Post Hearing Note following the Open Floor hearing 5th March 2019

Deadline 7 submission

Dafydd Griffiths on behalf of the NACP

Post Hearing Response – Deadline 7
Route of the Lôn Las Copr / Copper Trail
Dafydd Griffiths on behalf of the NACP

Figure 1-4 A5025 Off-line Highway Improvements Section 5

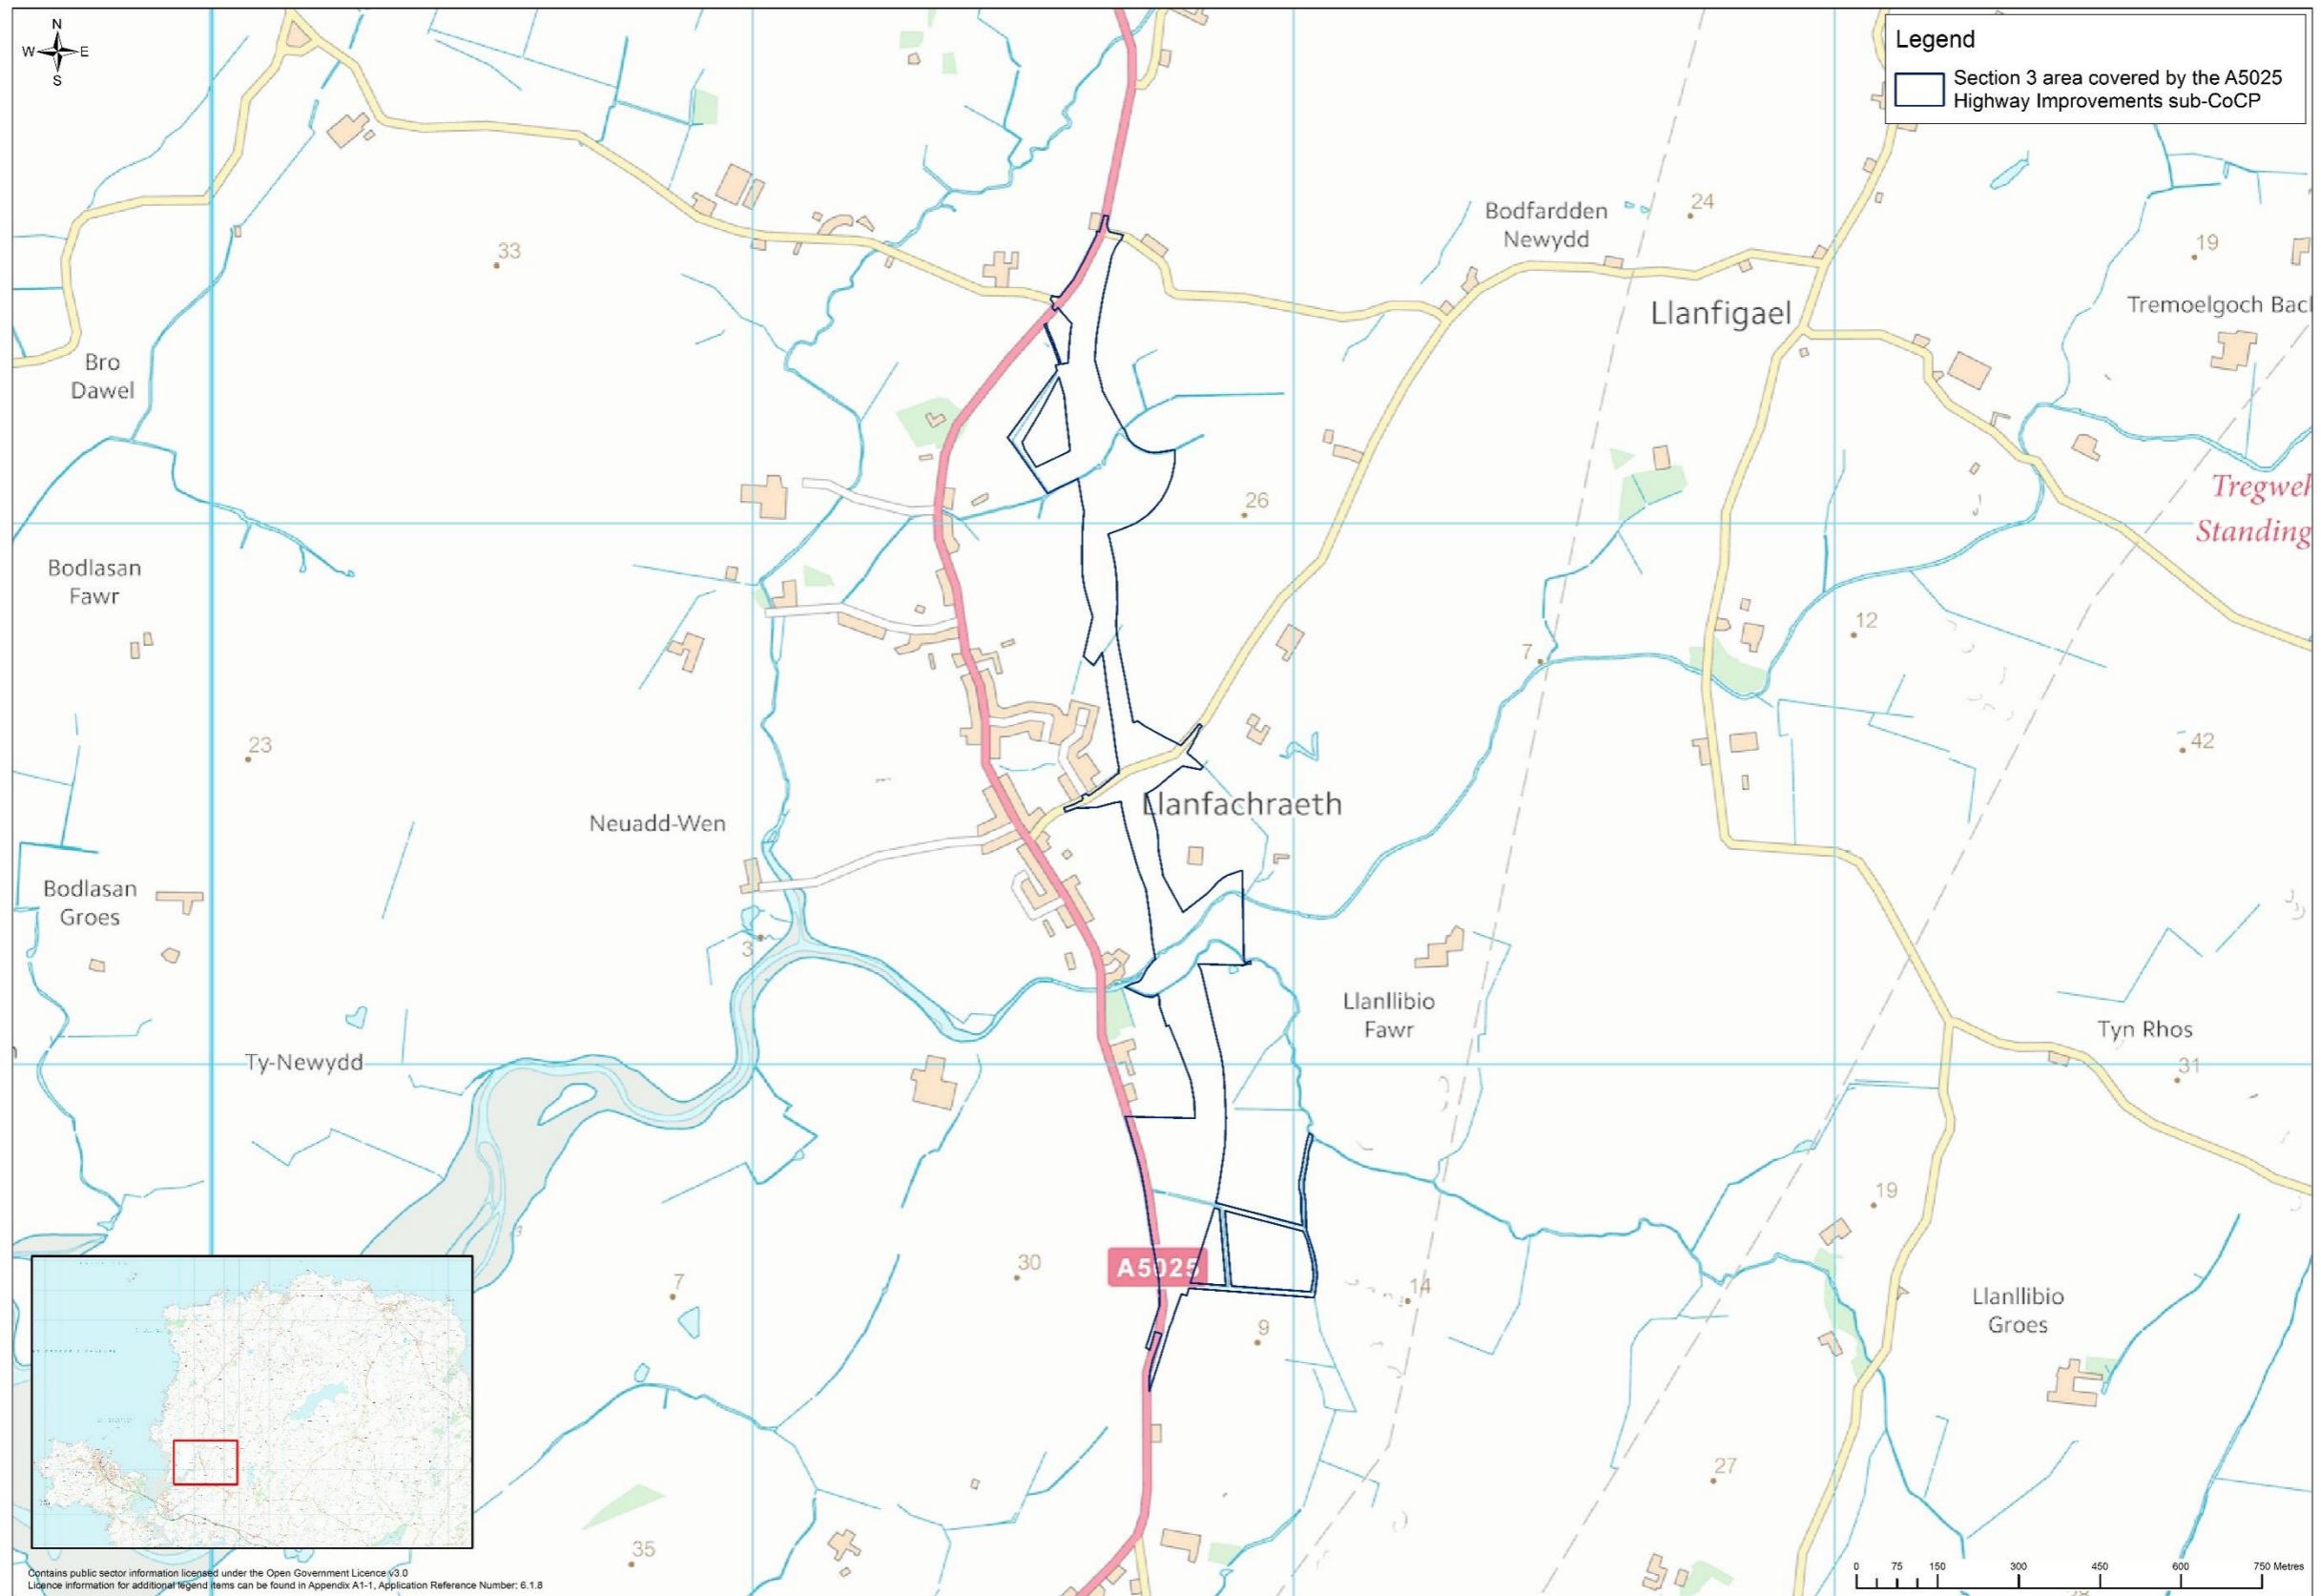
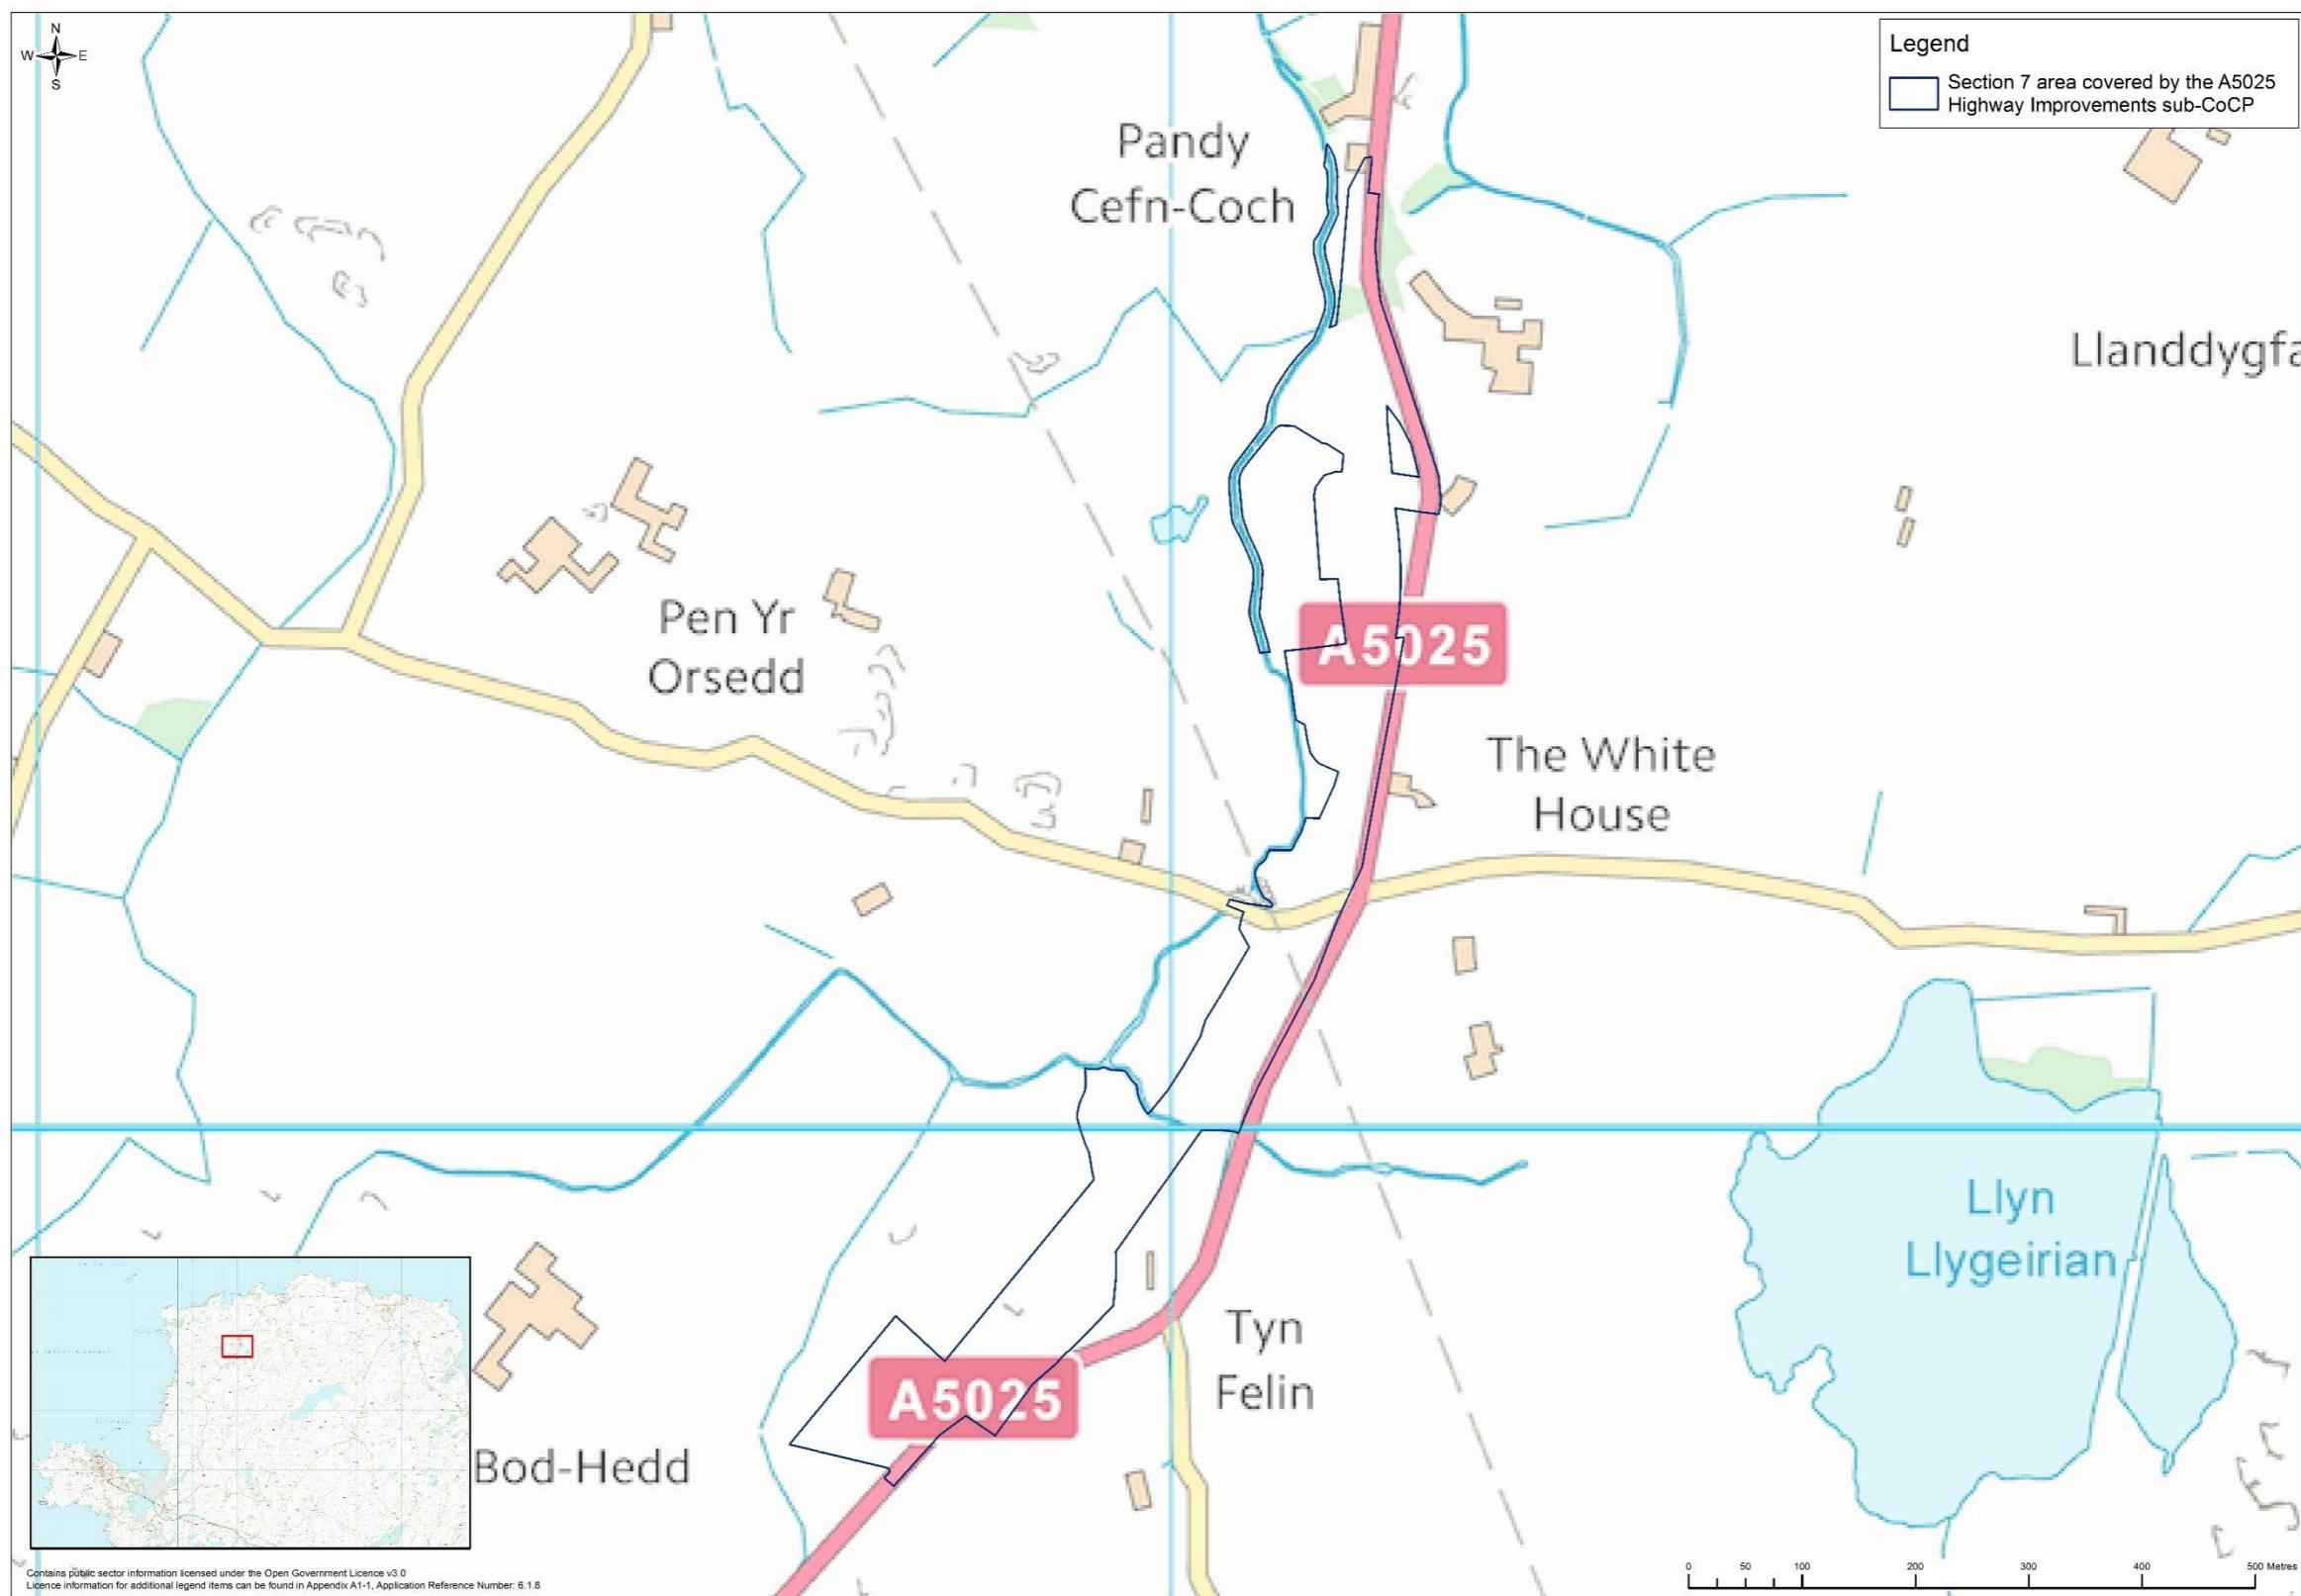
Concerns have been raised during the pre-application process and during the examination at deadline 2, deadline 4 and deadline 6 that improvements proposed on the A5025 between Valley, the WNDA and Cemaes have not given sufficient weight to the impact on Non-motorised Users (NMU).

At deadline 4 the NACP identified specific sections of the A5025 where the applicant was proposing NMU infrastructure but in the opinion of the NACP the proposals were inadequate. The NACP also identified other specific sections of the A5025 where the applicant currently had no NMU infrastructure proposals but where, in NACP's view, mitigation was needed. At deadline 6, as a follow up to the Accompanied Site Inspection that took place on the 14th February 2019, the NACP submitted further comments and proposals on the most appropriate route for the Lôn Las Copr / Copper Trail during both the construction and operational phases of the Wylfa Newydd Power Station.

The NACP are of the view that the Lôn Las Copr / Copper Trail could and should be routed as close to its original route as is possible and desirable during both the construction and operational phases of the Wylfa Newydd project.
